KITITAS COUNTY

MEMORANDUM

TO: All Staff
FROM: Justin Turnbull, County Surveyor
DATE: March 27, 2017
SUBJECT: County Survey Review of Preliminary Plat LP-17-00003 (Suncadia)

JOB NO.:	998-719-016
DWG. NAME:	PP-01
DESIGNED BY:	JJH
DRAWN BY:	LGB
CHECKED BY:	
DATE:	03/06/2017
PRINT DATE:	
SHEET	
PP-01

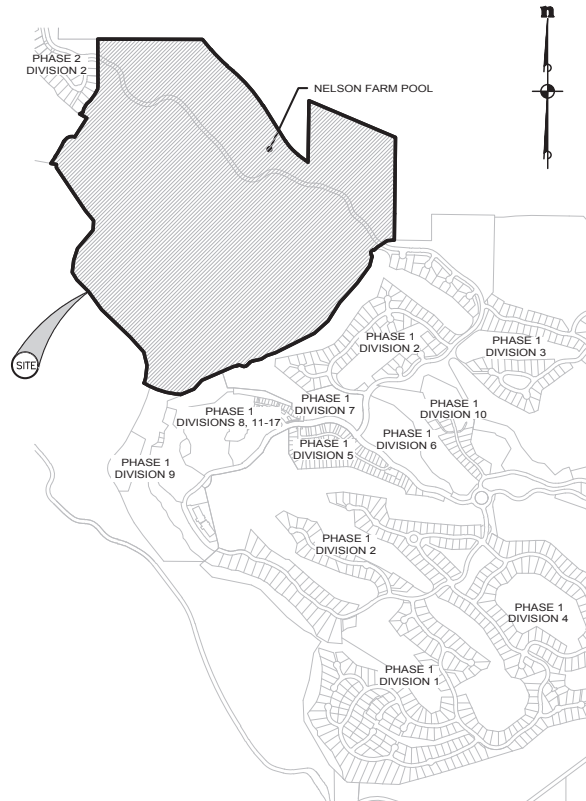
1. Lot and road dimensions to be shown on the face of the plat (KCC:16012.020(8)).
2. The legal description on the face of the map has some minor discrepancies with the certificate of title. These should match, or a note provided explaining the differences.
3. County GIS shows 2 streams running through the subject property which have not been shown on the face of the map (KCC:16.12.030(3)).
4. The FEMA flood limits should be shown. These appear to be a close match to Parcel OS-9. (KCC:16.12.030(3)).
5. The area shown as Tract NF-2 appears to have structures and fencing. These should be shown. (KCC:16.12.030(4))
